From: Simon Davis <Simon.Davis@arun.gov.uk>
Sent: 16 June 2021 13:58
To: Planning.Responses <Planning.Responses@arun.gov.uk>
Subject: FW: Drove Lane, Yapton (Y/49/21/RES) - Comments

Further Landscape Comments (ref play area proposals)

From: Sue Howell <Sue.Howell@arun.gov.uk>
Sent: 27 May 2021 16:25
To: Simon Davis <Simon.Davis@arun.gov.uk>
Subject: FW: Drove Lane, Yapton (Y/49/21/RES) - Comments

We have been reviewing comments on the Planning Portal on our revised Reserved Matters submission (Ref. Y/49/21/RES) at Drove Lane, Yapton. We noted that you have requested further detail regarding the play detail, specification and maintenance.

PROJECT TITLE:
**Drove Lane,
Yapton LAP 4**

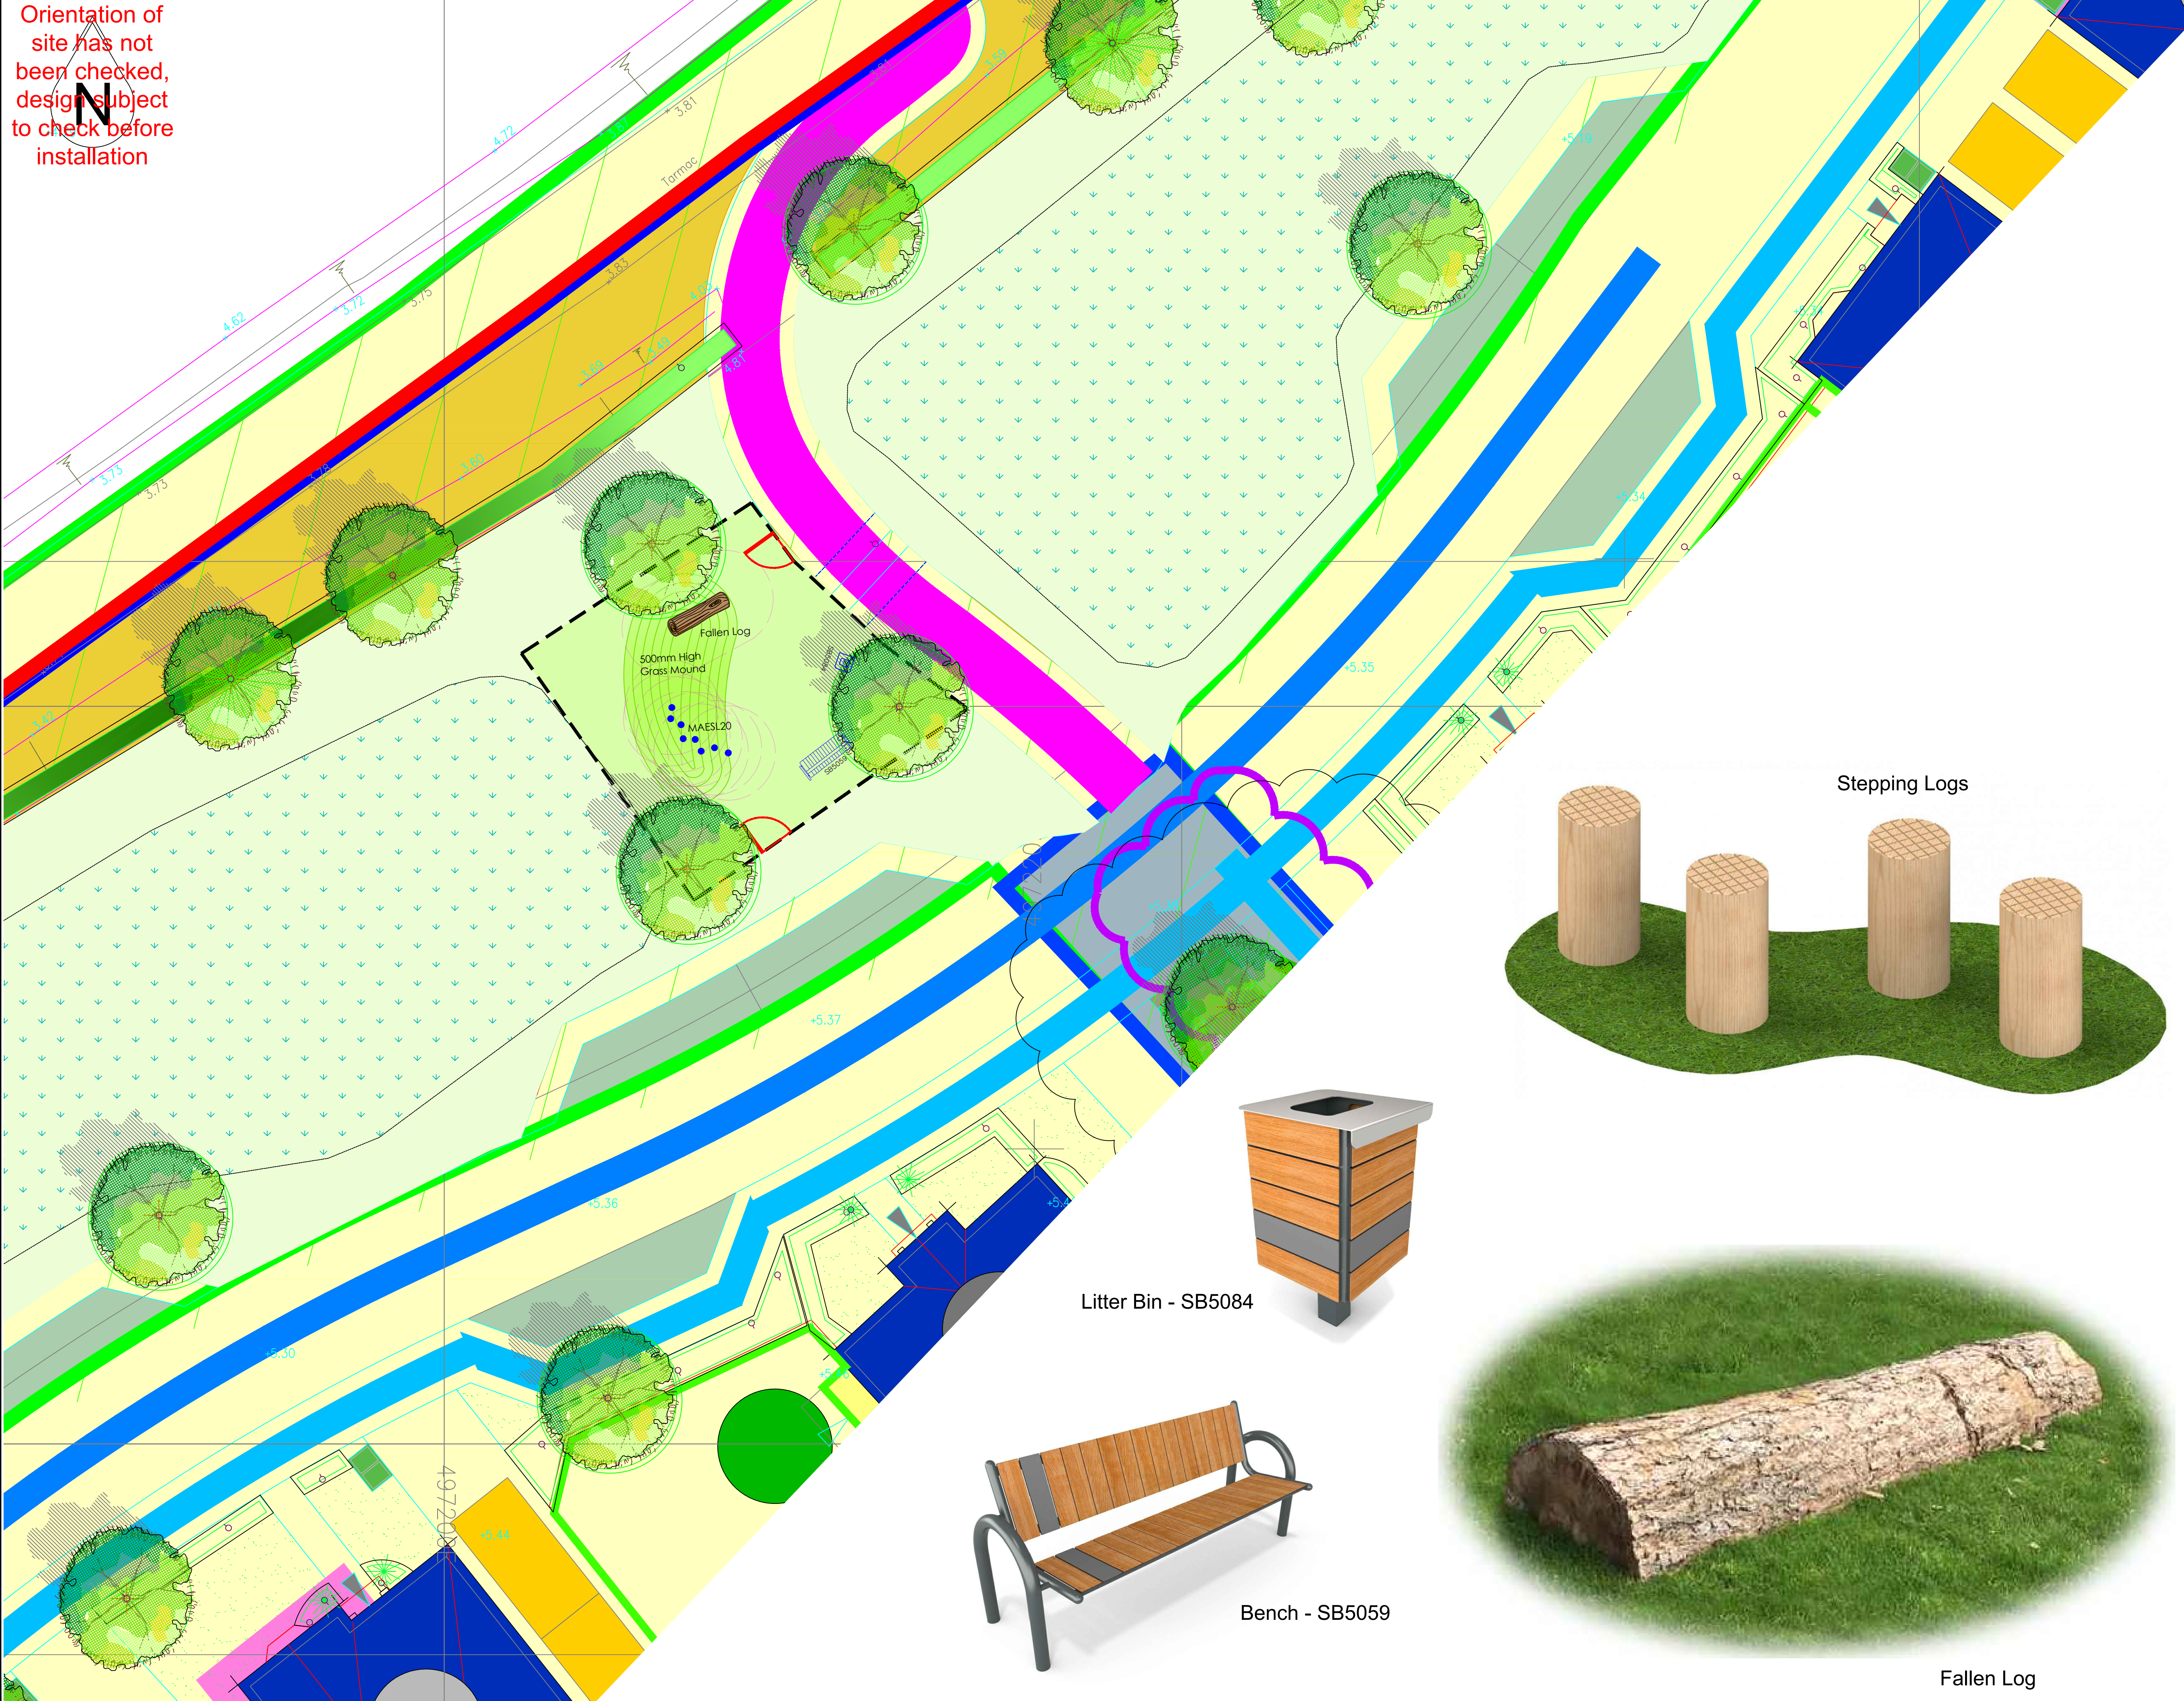
The fencing for the LAPs as shown would appear appropriate in these instances because of the proximity to the SuDS features, this can also be caveated with recommendation for RoSPA inspection of these in these locations.

Recommendation to approve LEAP and LAP detail and Maintenance provision notified under application Y/49/21/RES.
